**City of Albuquerque**  
**Parks and Recreation Department**  
PO Box 1293, Albuquerque, New Mexico 87103  
Inter-Office Correspondence

Development Review Board Comments

**Project Number:** 1002342  
**Application Number:** 03DRB-02178

**RE: Petroglyph Gardens/final plat**

PRELIMINARY PLAT FOR  
**PETROGLYPH GARDENS SUBDIVISION**

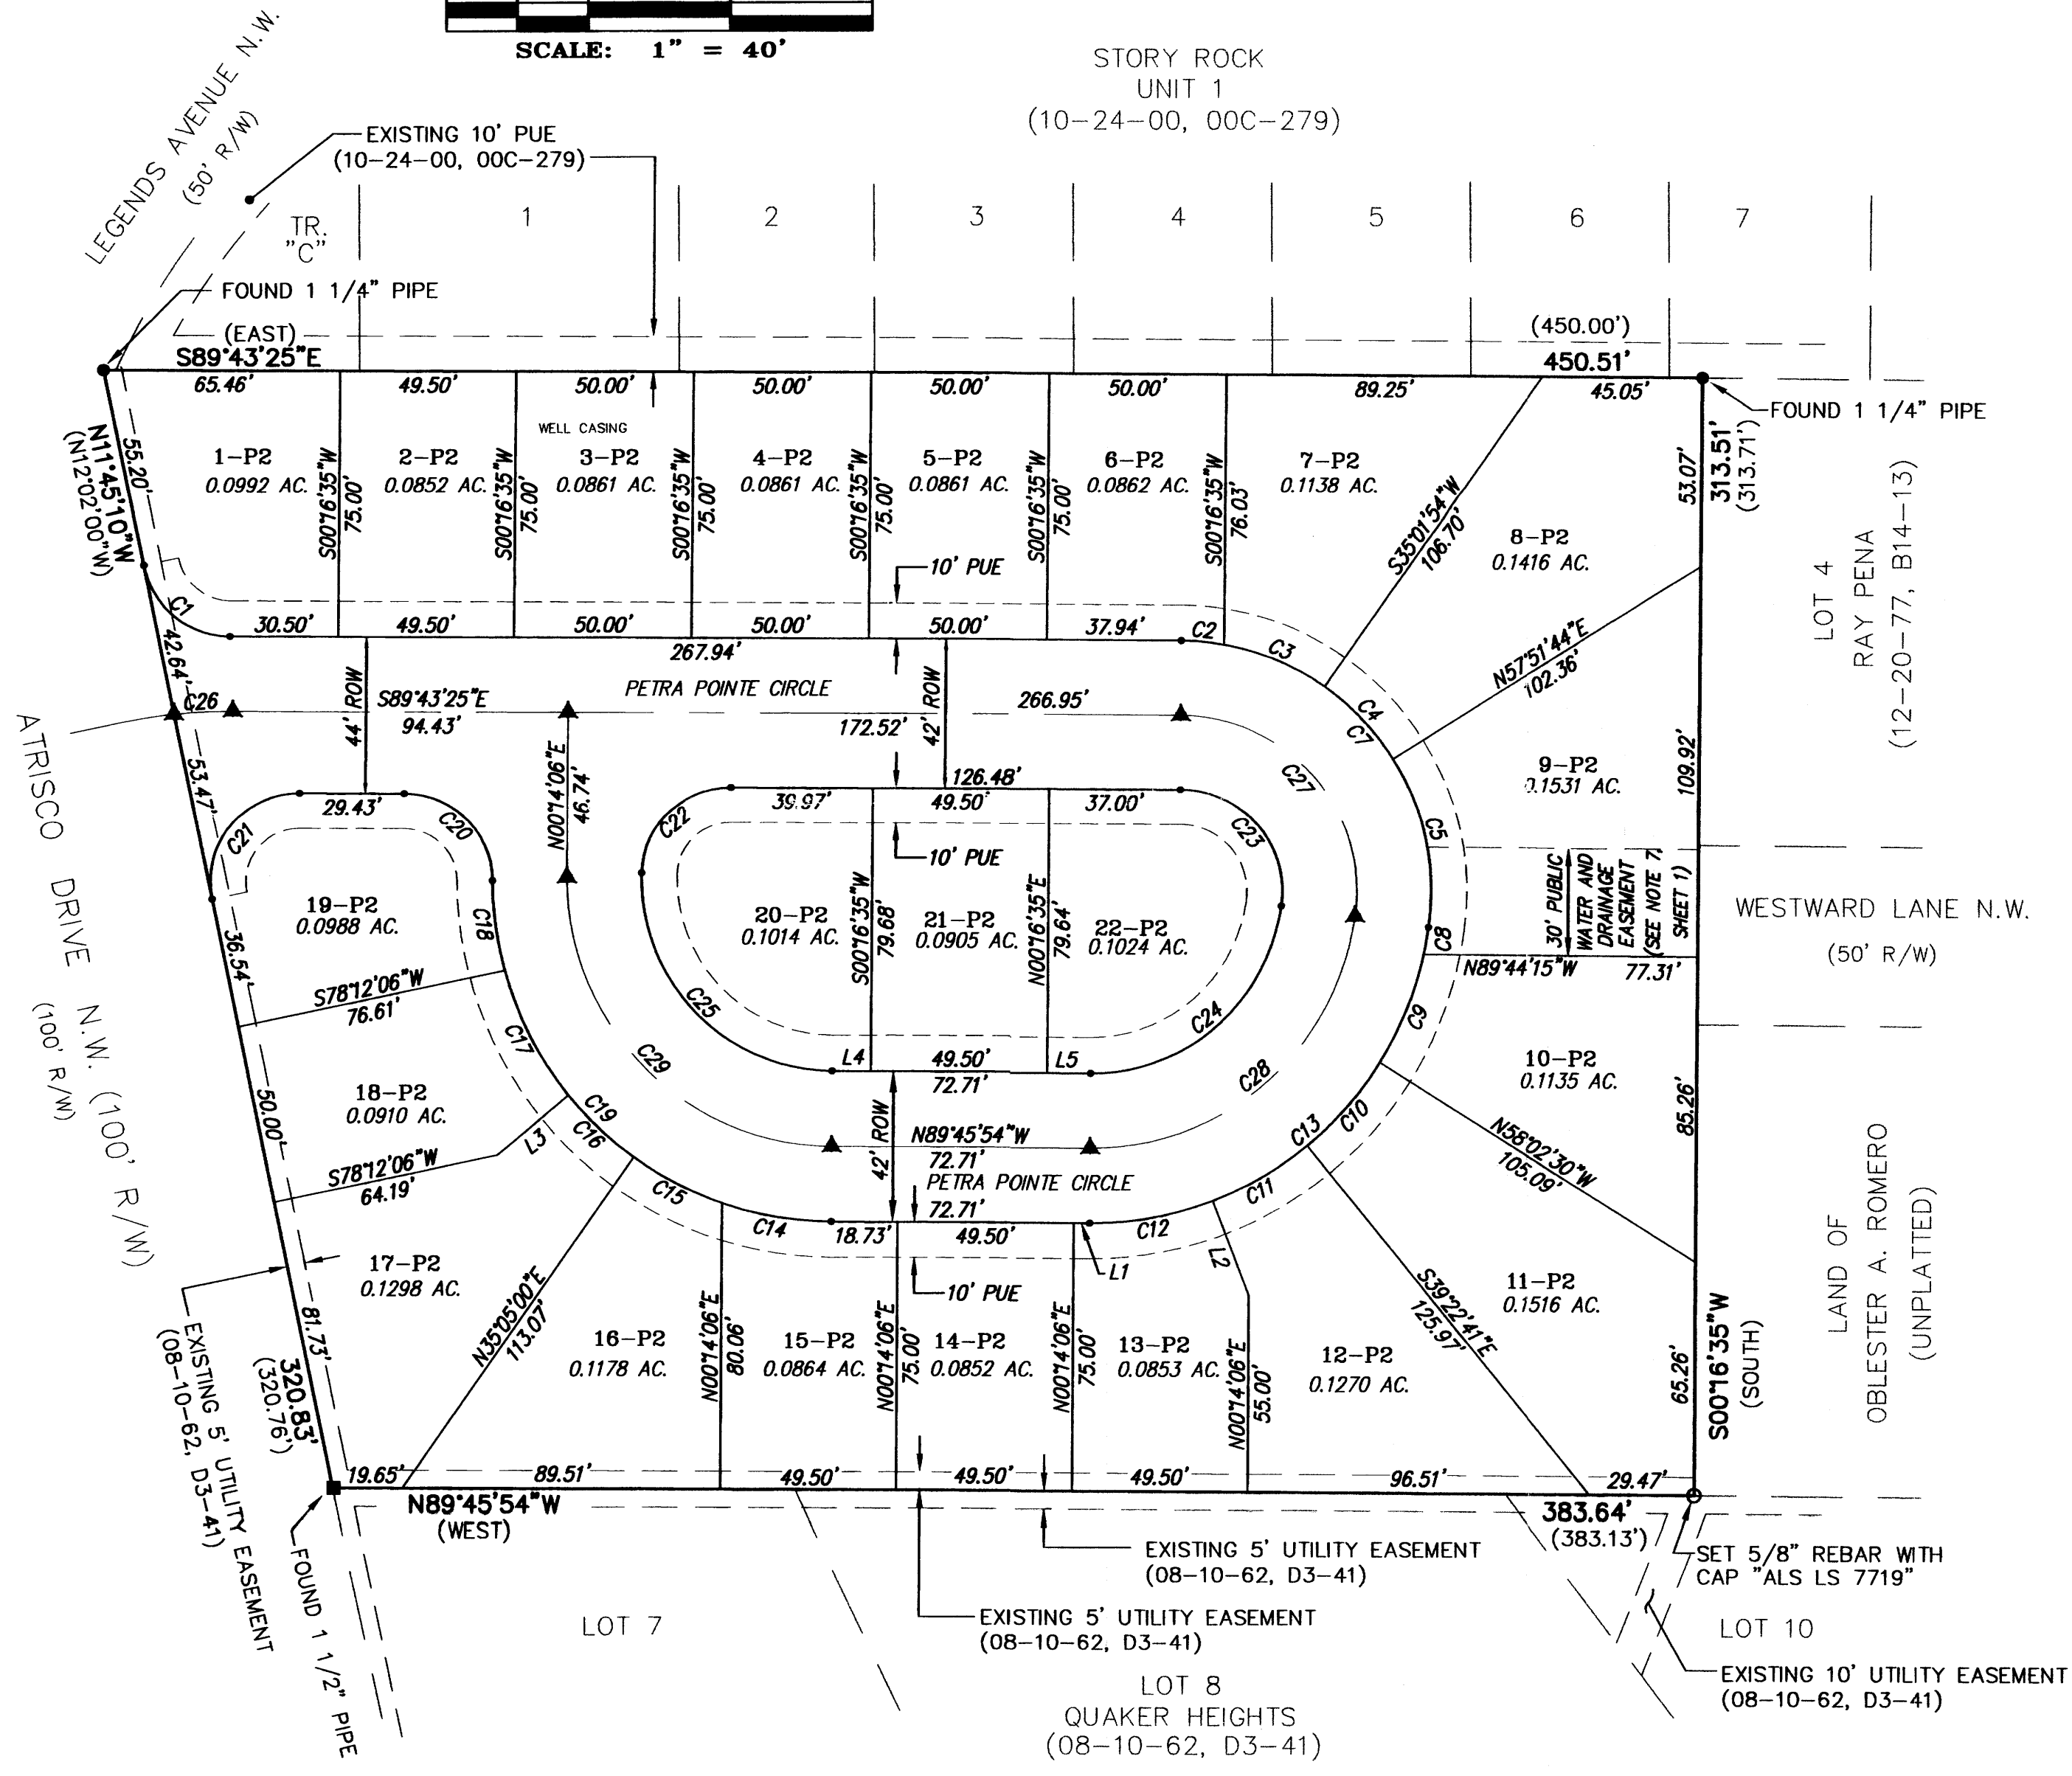
- 1) Adequate right-of-way is dedicated to provide for driver visibility at the intersection of Petra Pointe Circle and Atrisco.
- 2) A Subdivision Design Variance for Curve 27 is requested and approved prior to final plat approval.

Adequate visibility needs to be demonstrated and provided for at the entrance.

PLAT FOR  
**PETROGLYPH GARDENS SUBDIVISION**  
 WITHIN  
 SECTION 35  
 TOWNSHIP 11 NORTH, RANGE 2 EAST, NMPM  
 CITY OF ALBUQUERQUE  
 BERNALILLO COUNTY, NEW MEXICO  
 AUGUST, 2003

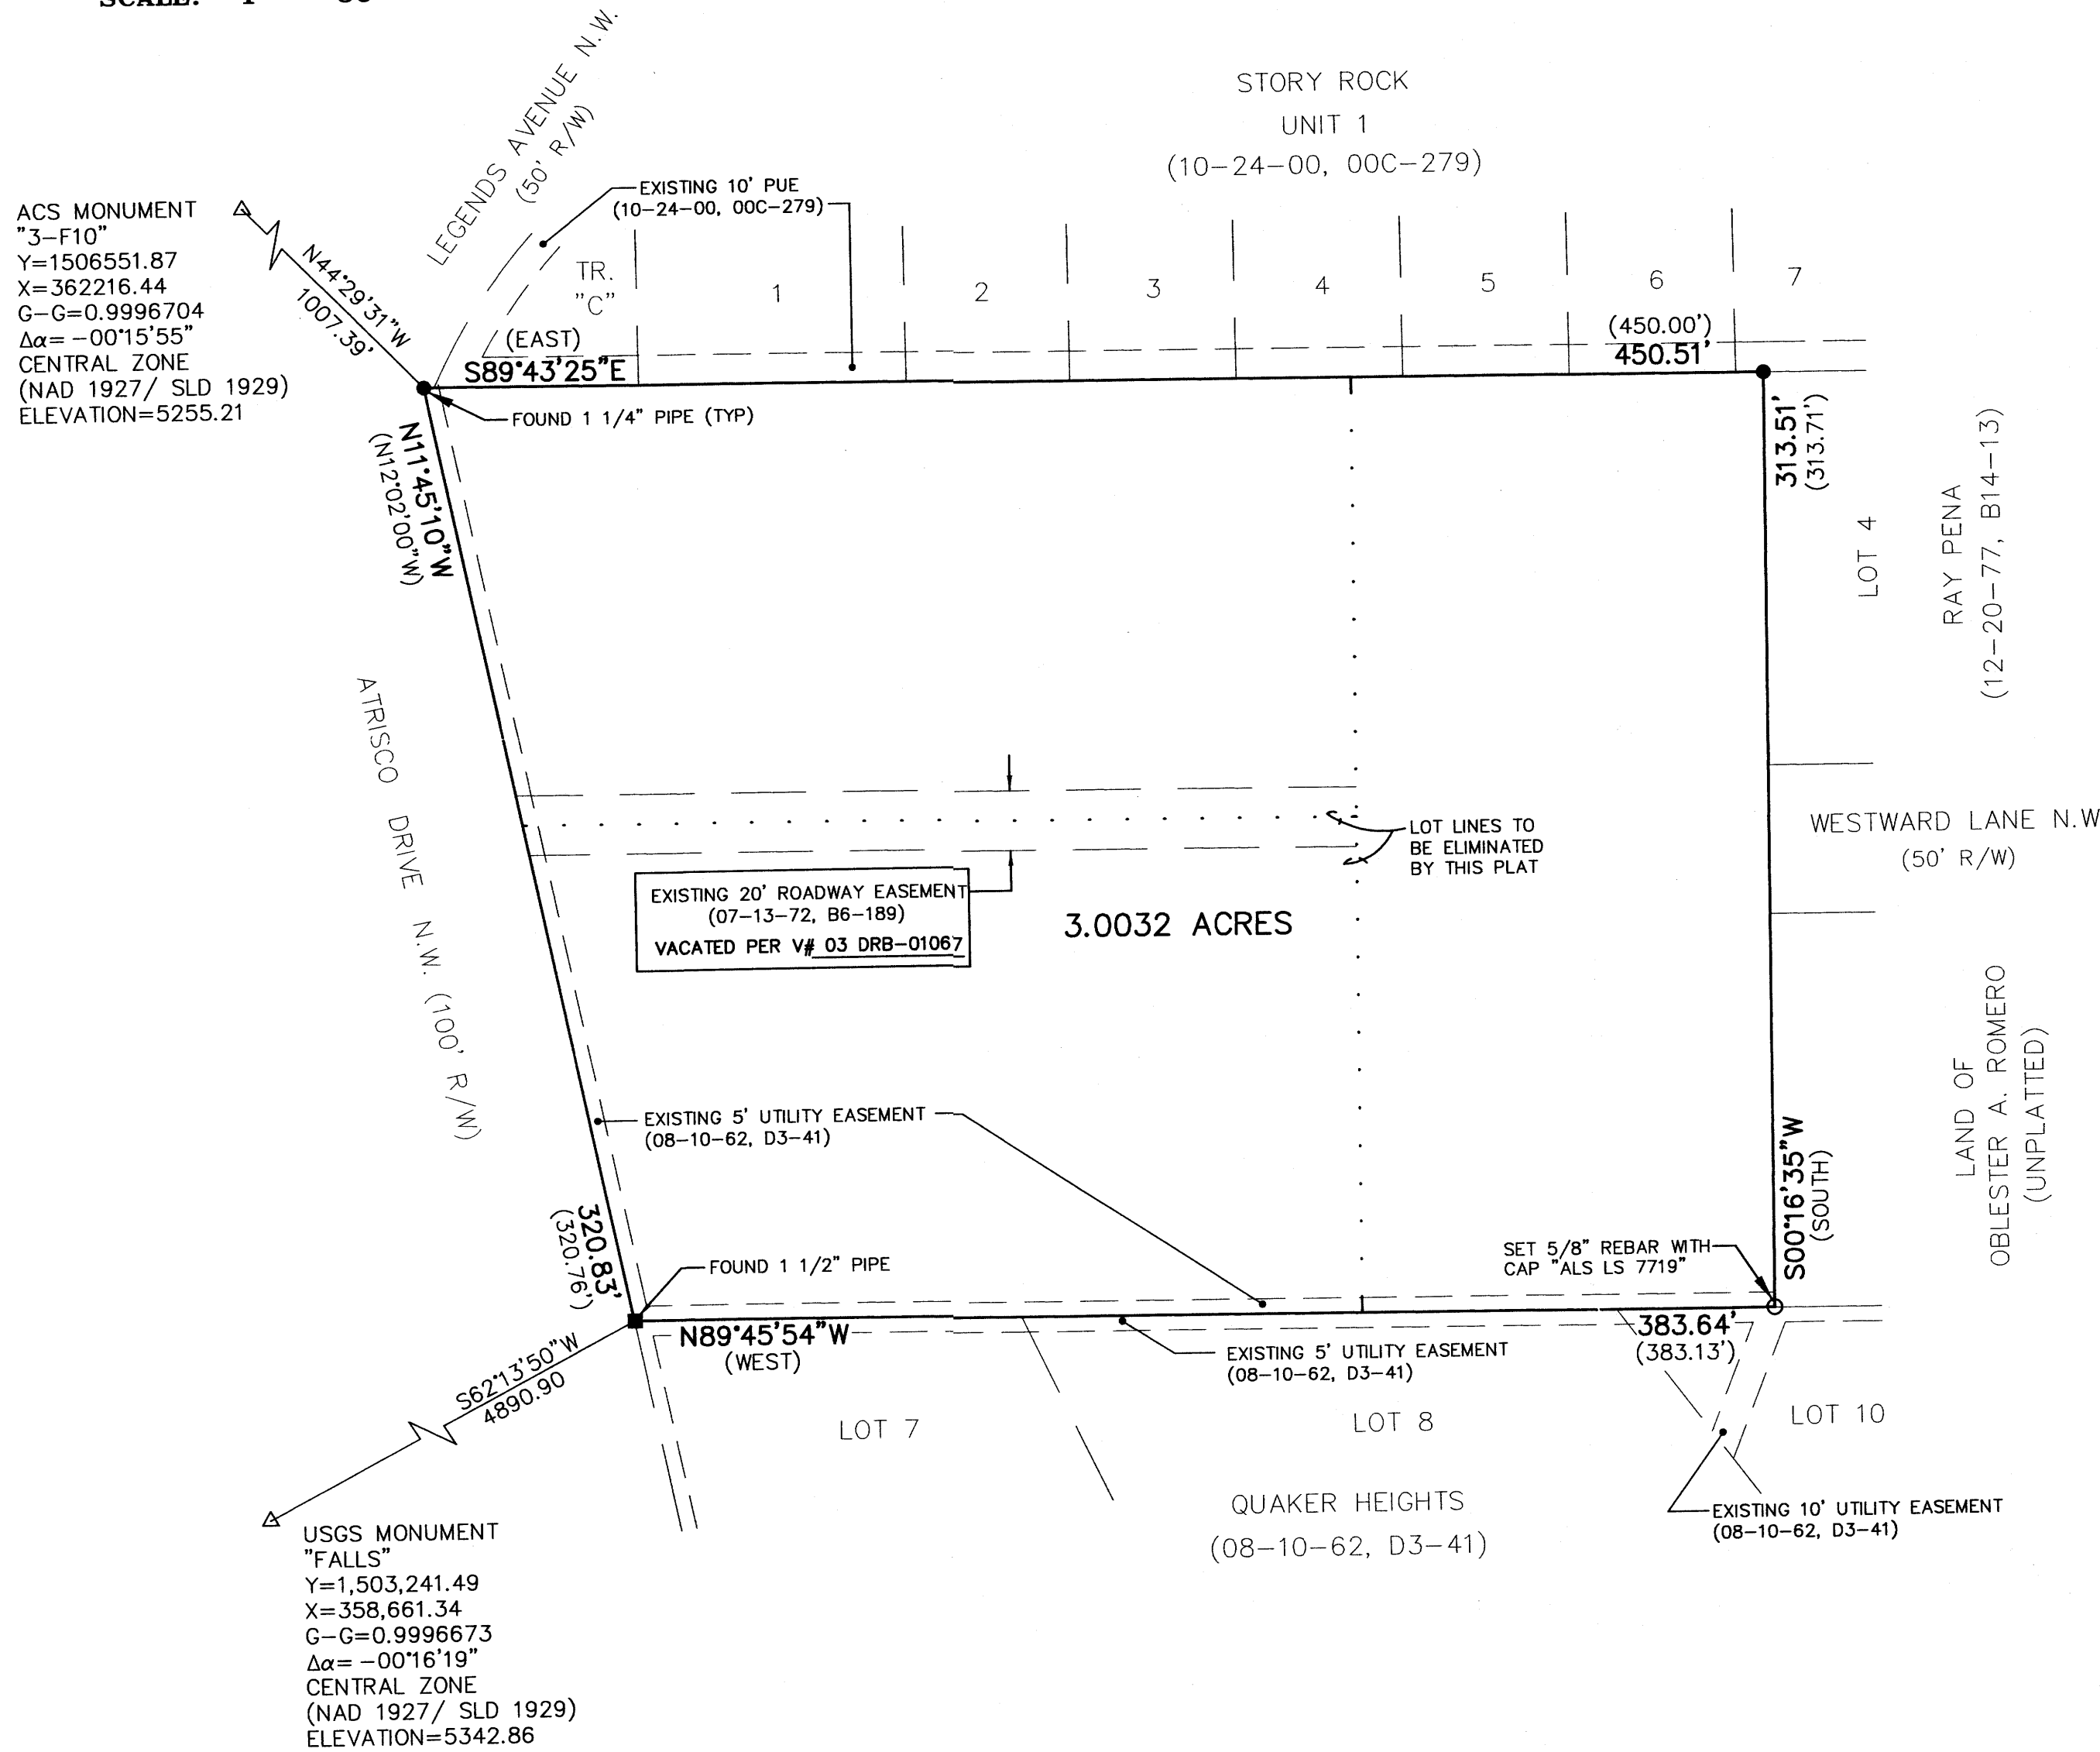
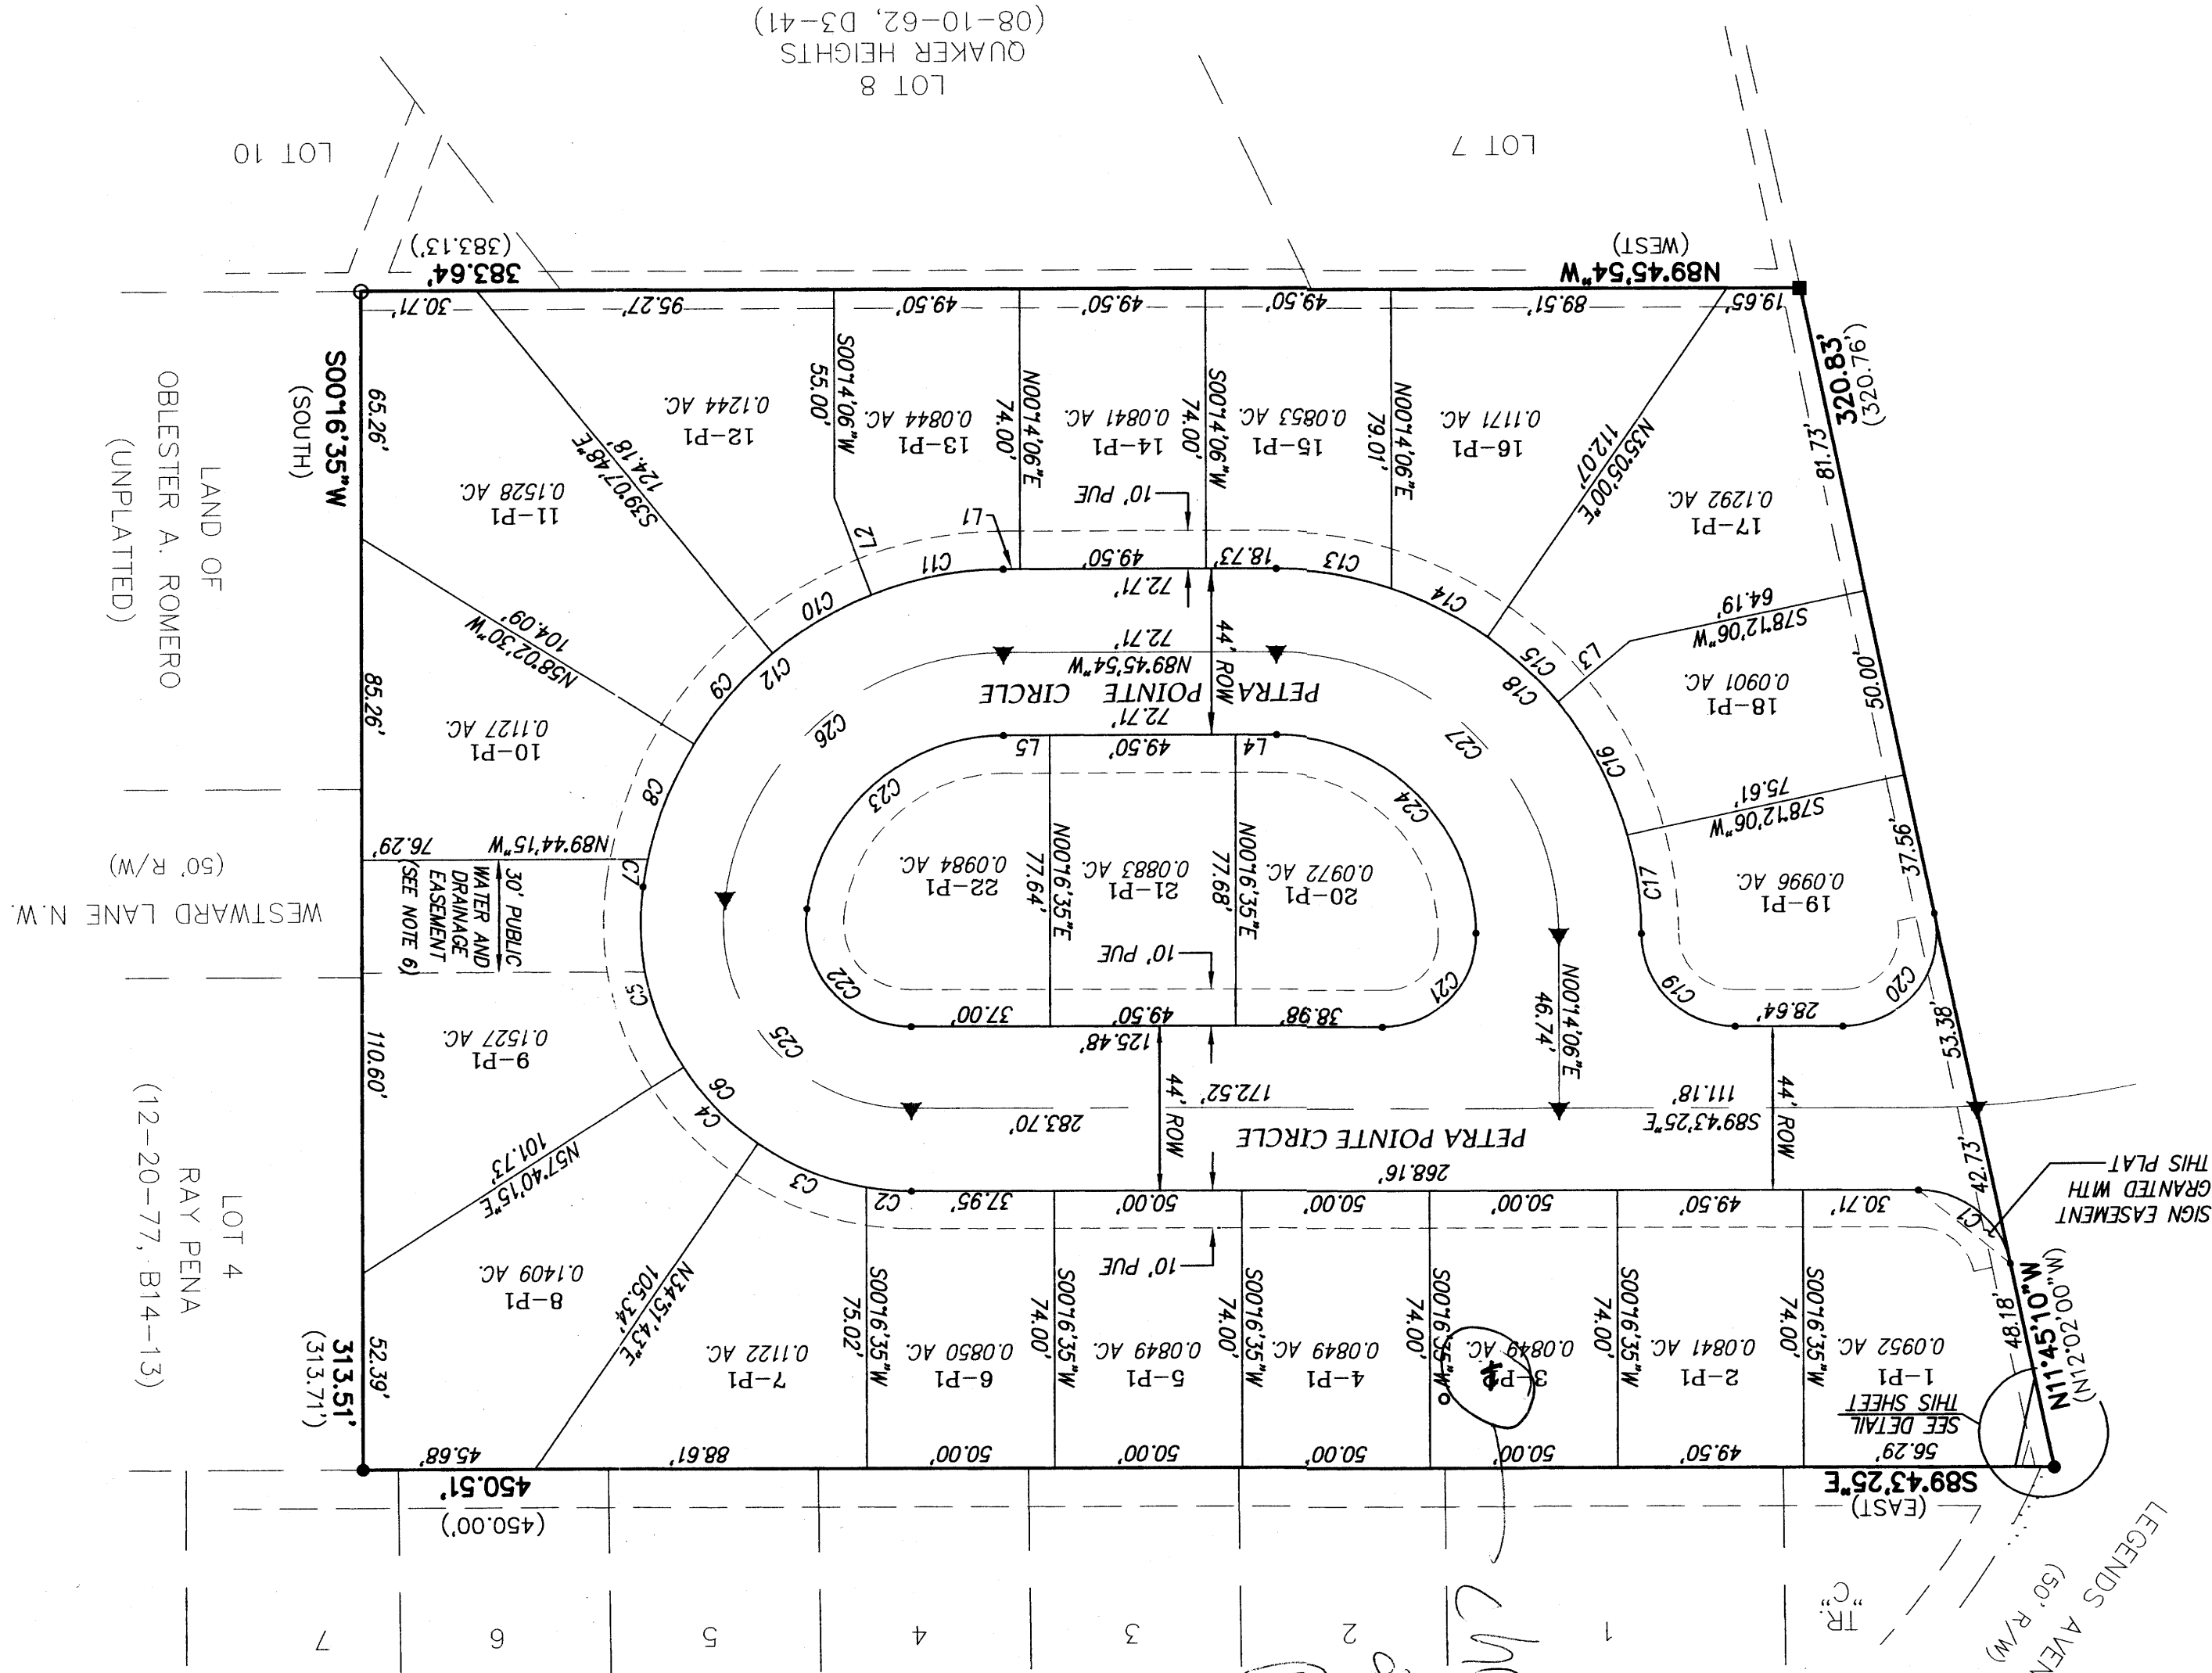
The lots now are P1 instead of P2? Why? Why is lot 3 now "PP"?
